Ár dTag | Our Ref.
TII24-128589

Re. Strategic Infrastructure Development – Proposed development of 9 no. wind turbines, 110kV substation and ancillary development located in the townlands of Snatty, Hurdlestown, Oatfield, Drumsillagh, Sallybank, Gortacullin, Aharinaghbeg, Knockshanvo, Cloontra, Cloghoolia, Ballycullen and others, County Clare and located in the townland of Court, County Limerick

ABP Case ref. PA03.320705

PROJECT: Knockshanvo Wind Farm Development

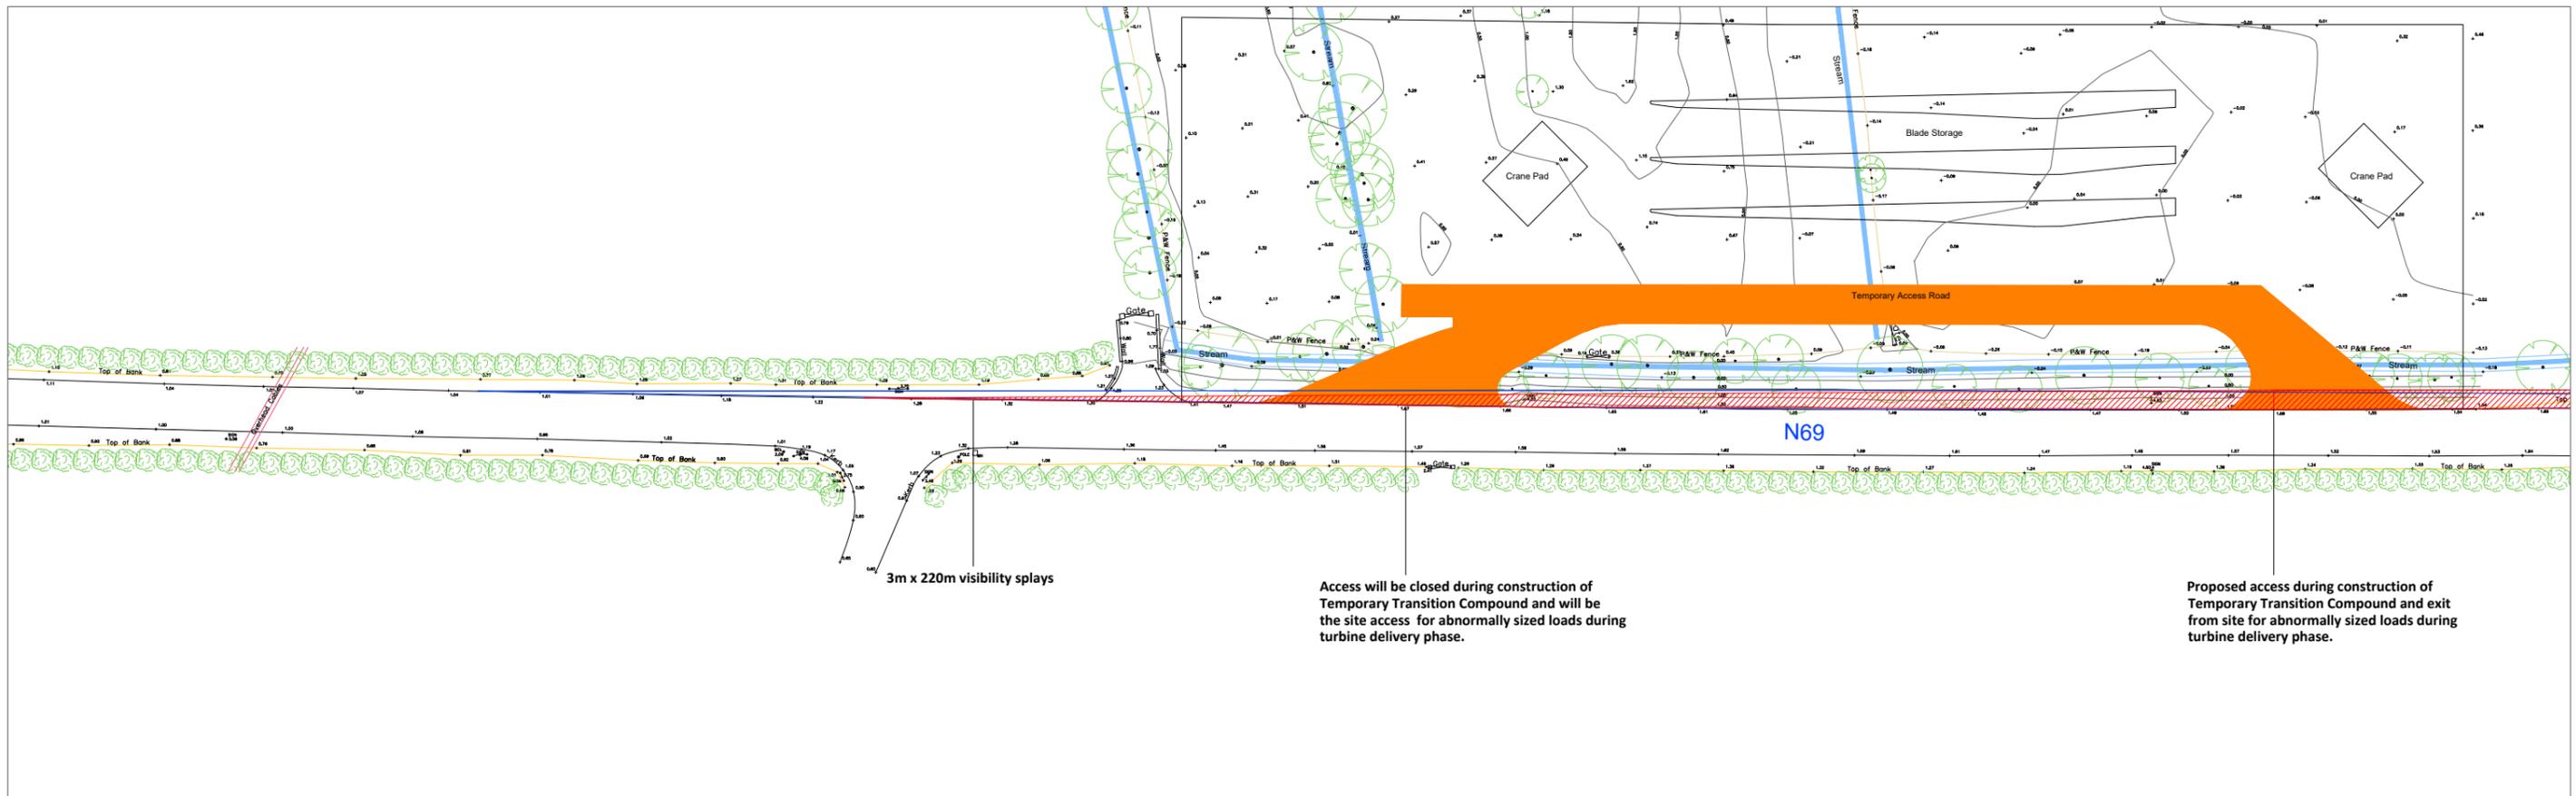
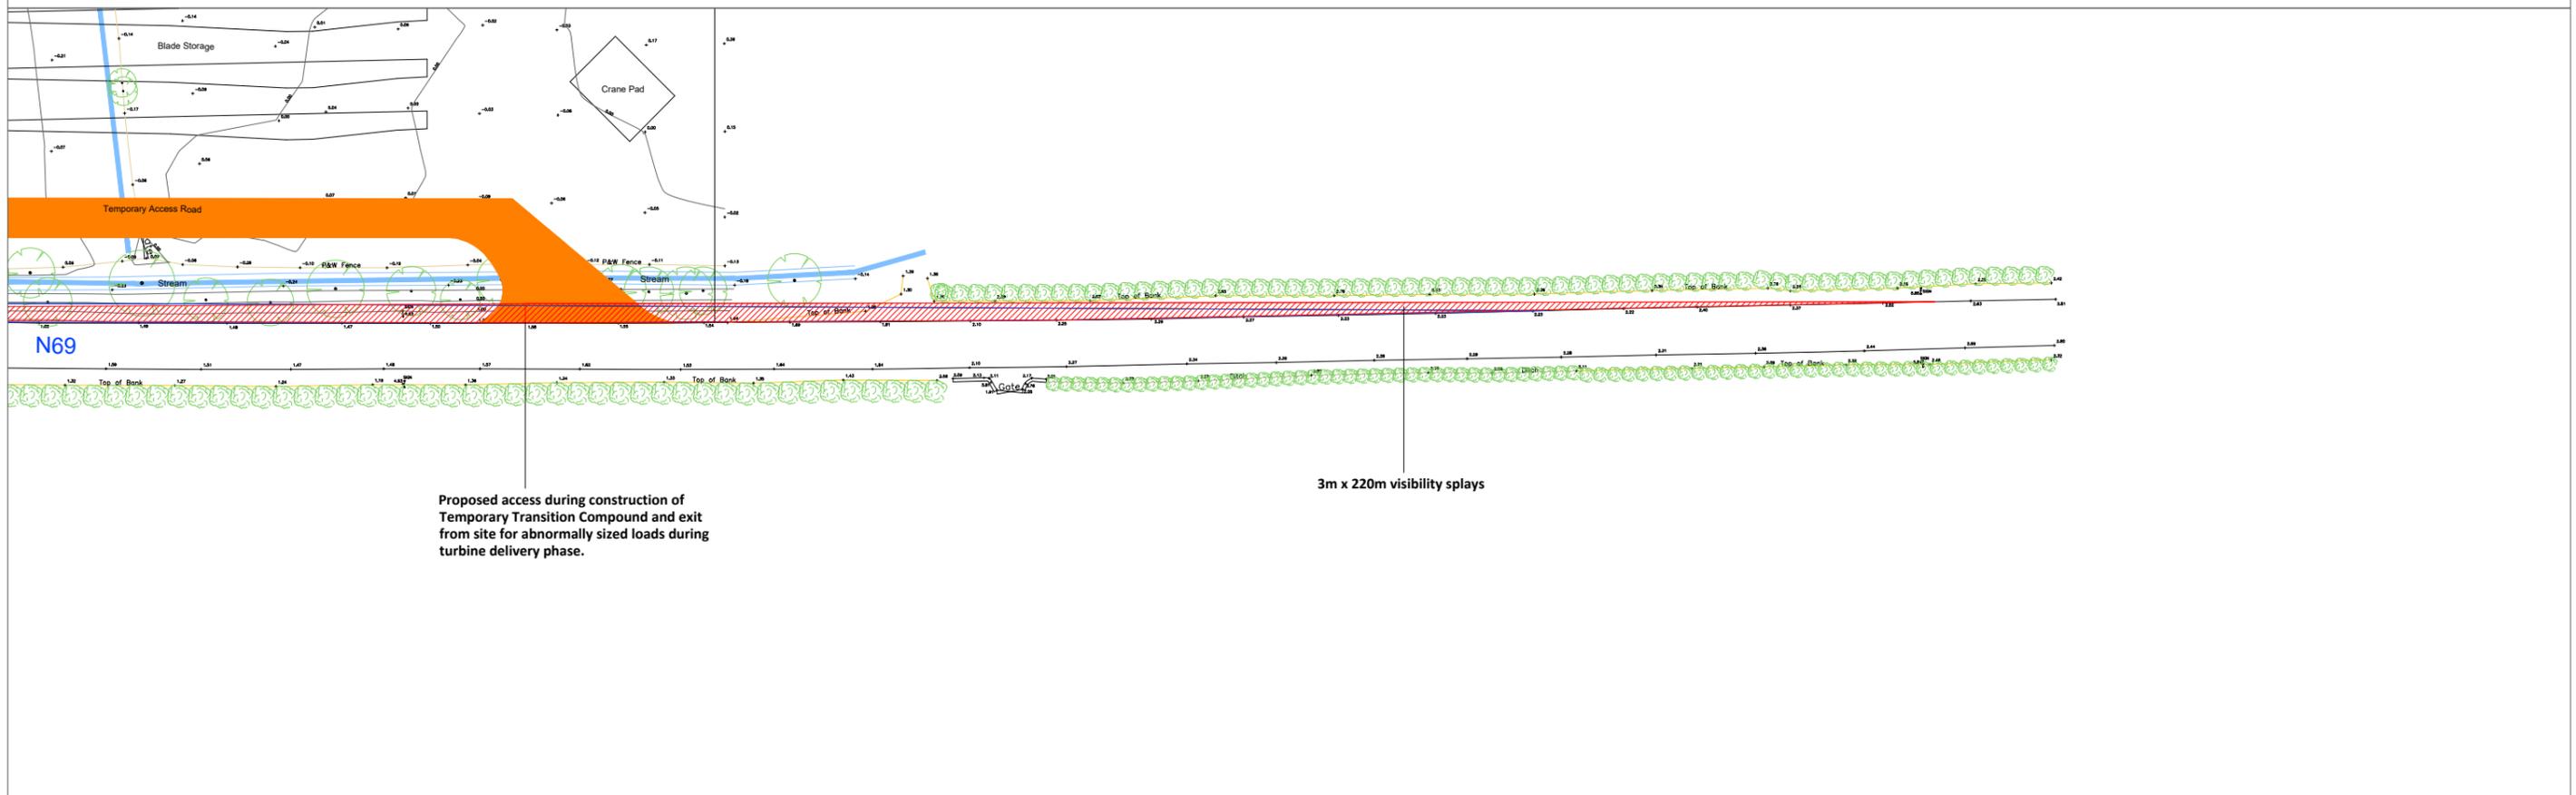
In relation to the subject application, the proposed development includes for construction of a remote compound with direct access to the N69, national road, at Court, Co. Limerick, at a location where a 100kph speed limit applies, to be utilised as a temporary transition compound facilitating turbine component delivery to site; Section 4.2.11.3 of the EIAR refers.

TII advises that this Design Report has not been submitted to TII in accordance with the requirements of TII Publications DN-GEO-03030 (Design Phase Procedure for Road Safety Improvement Schemes, Urban Renewal Schemes and Local Improvement Schemes). This is a concern due to the critical need to address road and public safety matters associated with the transportation of the turbines and the location of the temporary transition compound access to the site on the N69, national road.

The Board is also advised that TII review of the Design Report may potentially require material changes and alteration to the proposal. Therefore, in the interests of road user safety, this matter requires urgent resolution by the applicant prior to a decision on this strategic infrastructure development application.

- No development shall commence onsite until the Design Report, included as Appendix 15-4 of the EIAR meets the requirements of TII Publications DN-GEO-03030 (Design Phase Procedure for Road Safety Improvement Schemes, Urban Renewal Schemes and Local Improvement Schemes). Details of TII approval shall be submitted to the planning authority prior to the commencement of development.

- The proposed access for the temporary transition compound shall be permitted for a temporary period to facilitate turbine component delivery only. The temporary transition compound and access to the N69, national road, shall be closed and lands and roadside boundaries reinstated on completion of the construction phase of development.

- An appropriate safety barrier to the transition compound access to the N69, national road, shall be installed and shall be closed when the transition compound is not in use for turbine component delivery.

- Any damage caused to the pavement on the existing national road at the temporary transition compound access from the N69, national road, due to the turning movement of abnormal loads (eg. tearing of the surface course) shall be rectified in accordance with TII Pavement Standards and details in this regard shall be agreed with the Road Authority prior to the commencement of any development on site.
